From:
To: [RichardA Gilbert; DCAdmin](#)
Subject: Hinchliffe Mill Amended Application 2021/62/90800/W
Date: 25 October 2022 00:00:28

Amended Application 2021/62/90800/W

In relation to the above I would like to request the current amended planning application, 2021/62/90800/W, for 19 dwellings is **refused** on several grounds.

HOUSE TYPE : UNIT 2

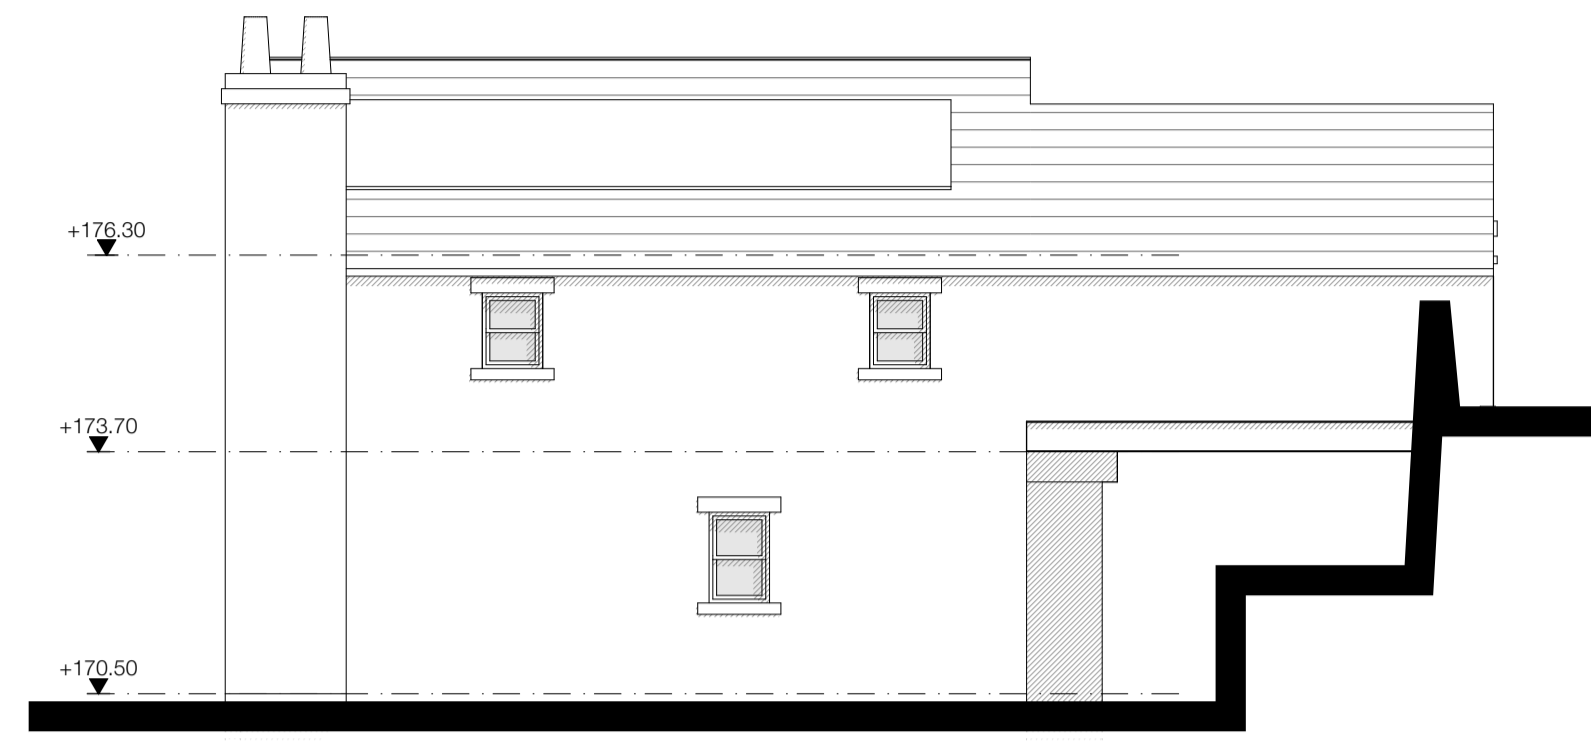
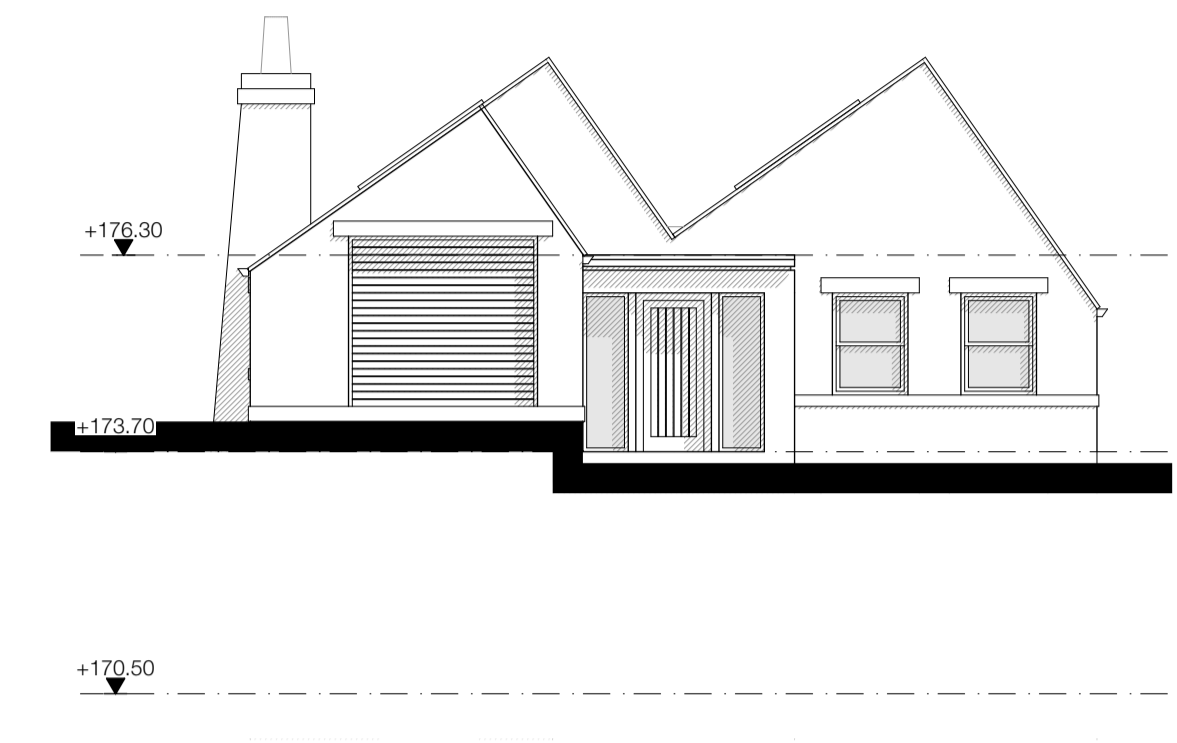
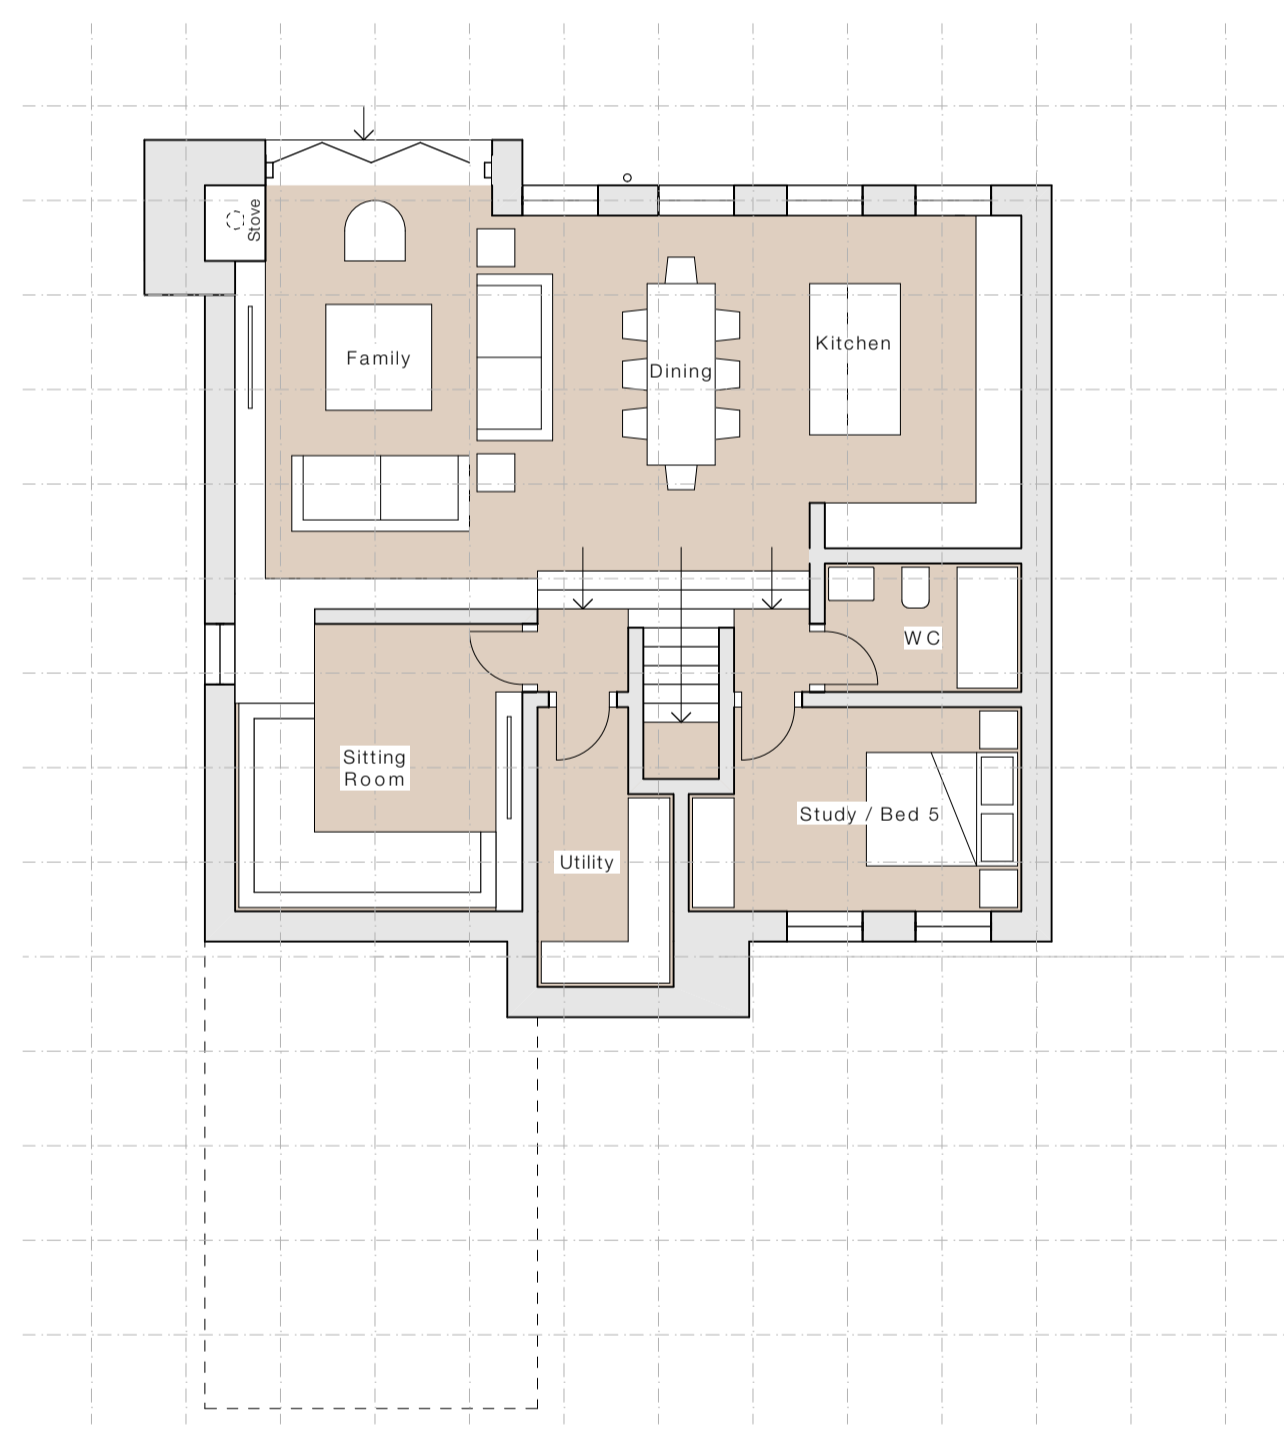
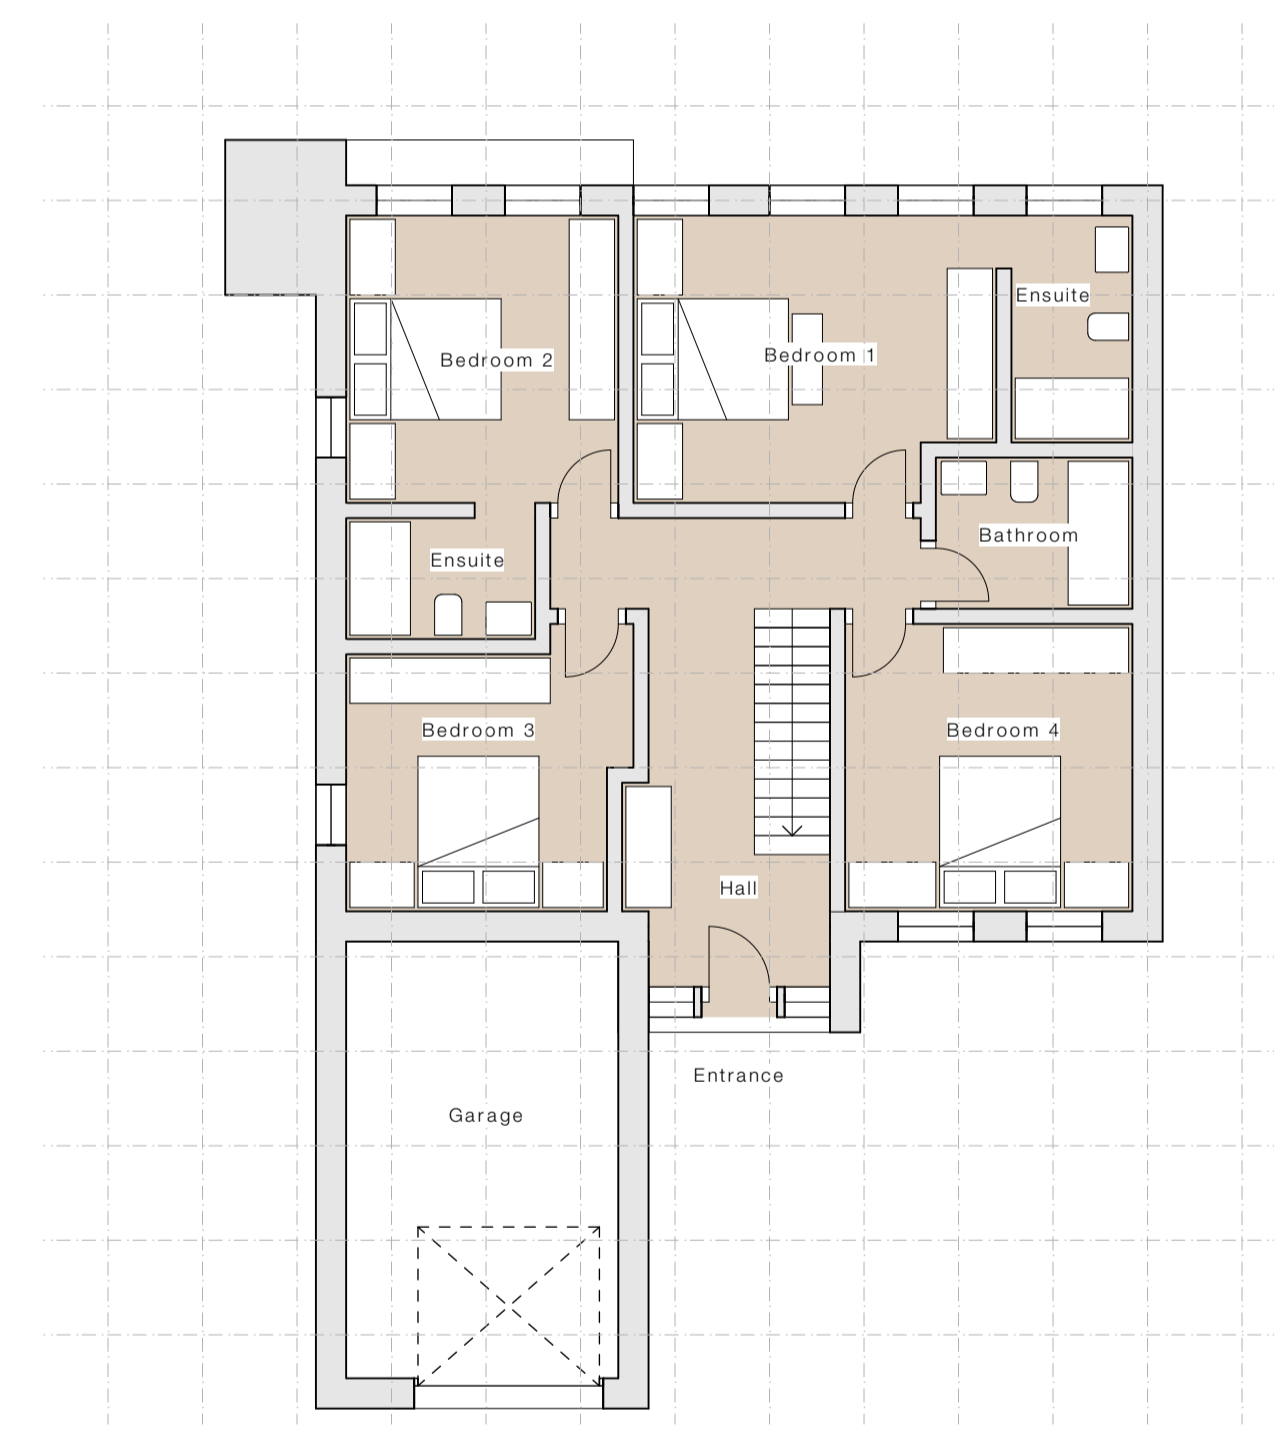
The 2 new proposed houses [1 and 2] on the dam banking along with a garage and 2 parking spaces

These houses are out of character with the mill and surrounding weavers cottages, many are listed buildings including the bridge over the river between Ford Gate and Dobb Lane.

These 2 houses should fit in with the surroundings rather than be of modern design like the others on this application.

**HOUSE TYPE : UNIT 16**

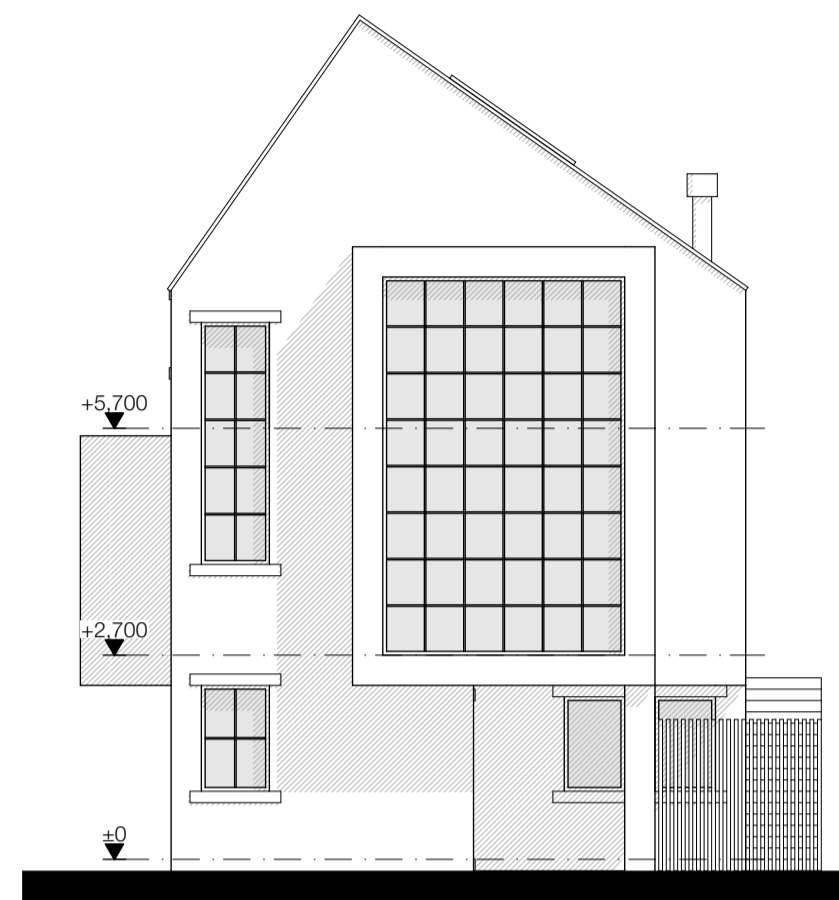
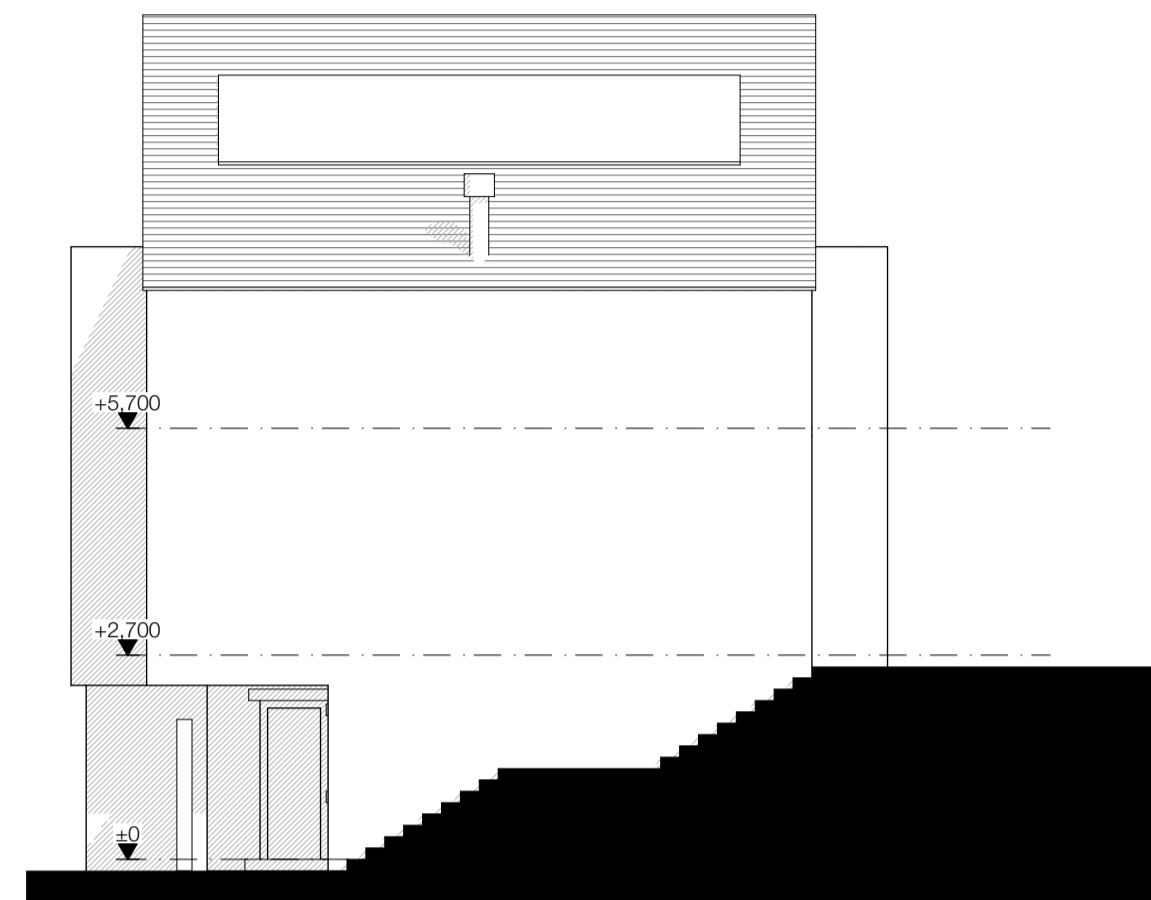
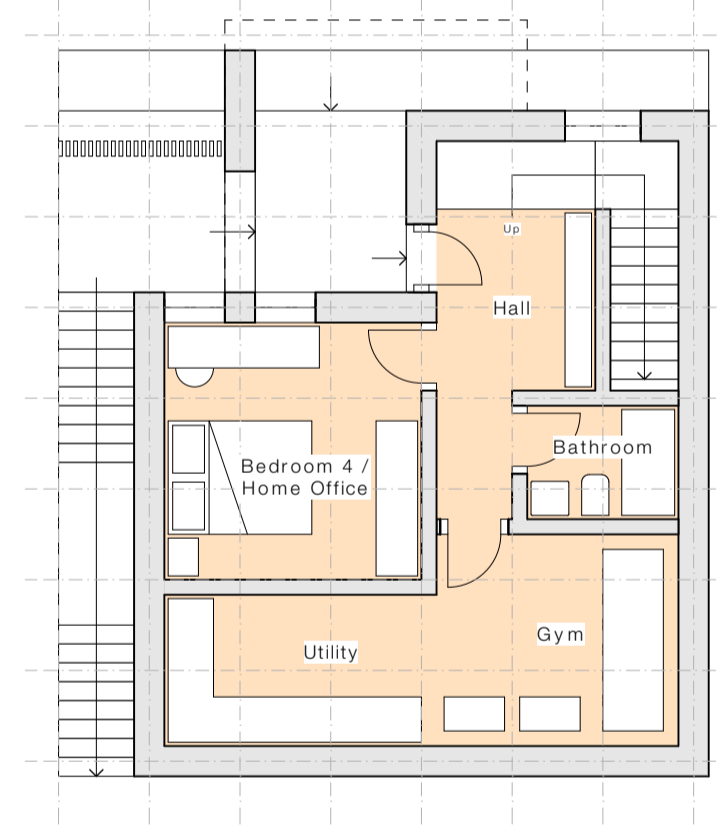
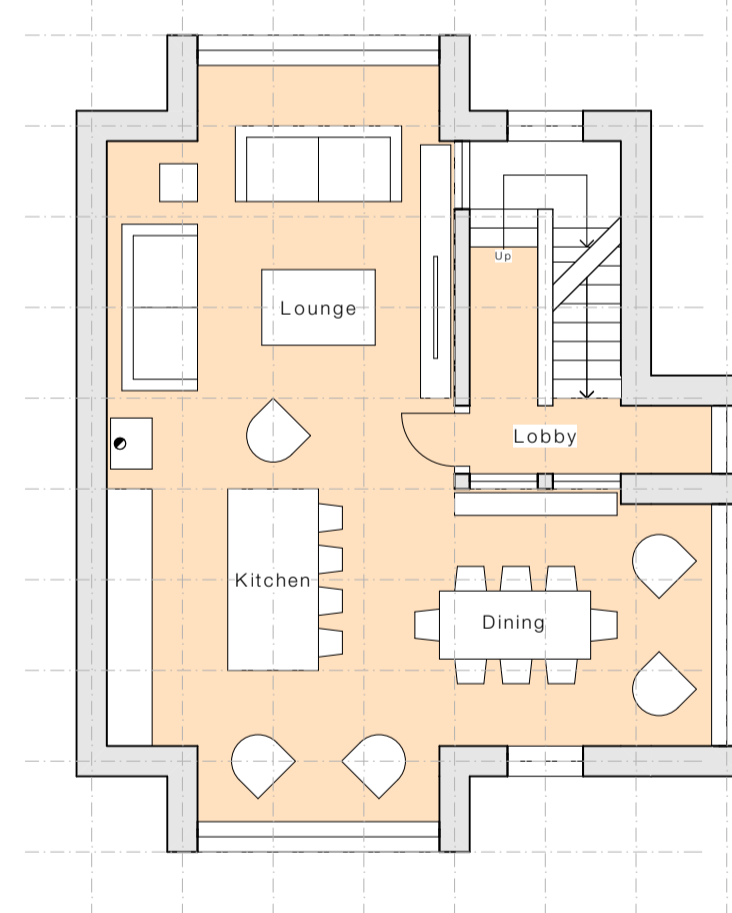
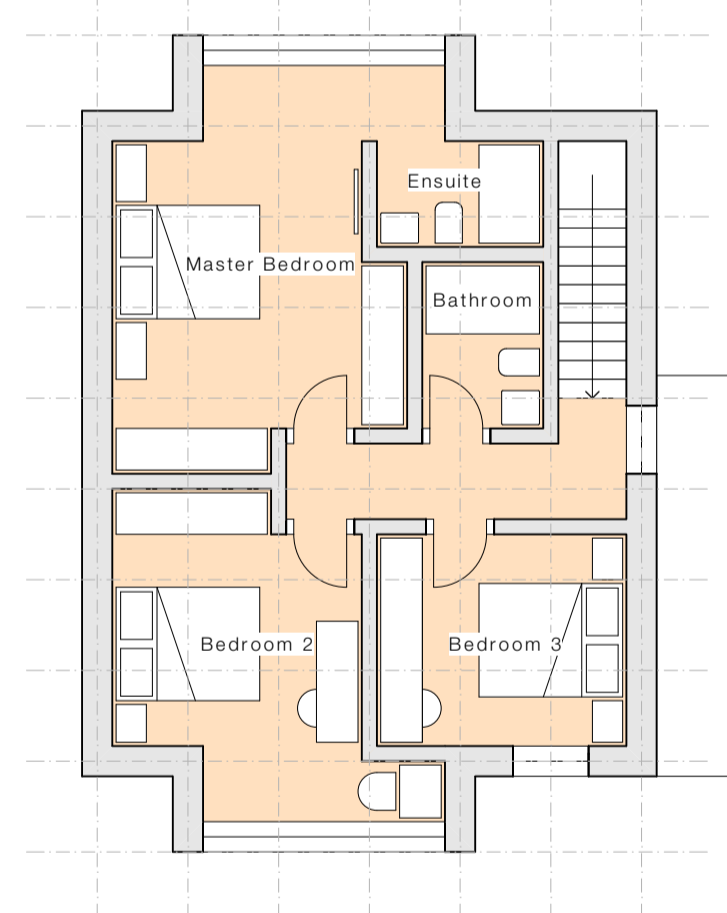
The 7 new houses behind the mill [10,11,12,13,14,15 and 16.

The 7 new proposed houses on top of the 7 townhouses in the mill are an over intensification of this area of the site, mainly due to highway issues on Water Street. I would like to see these greatly reduced in numbers and size. I would also strongly suggest that the strategic planning committee visit the site together so as to assess the topography of the proposed amended application.
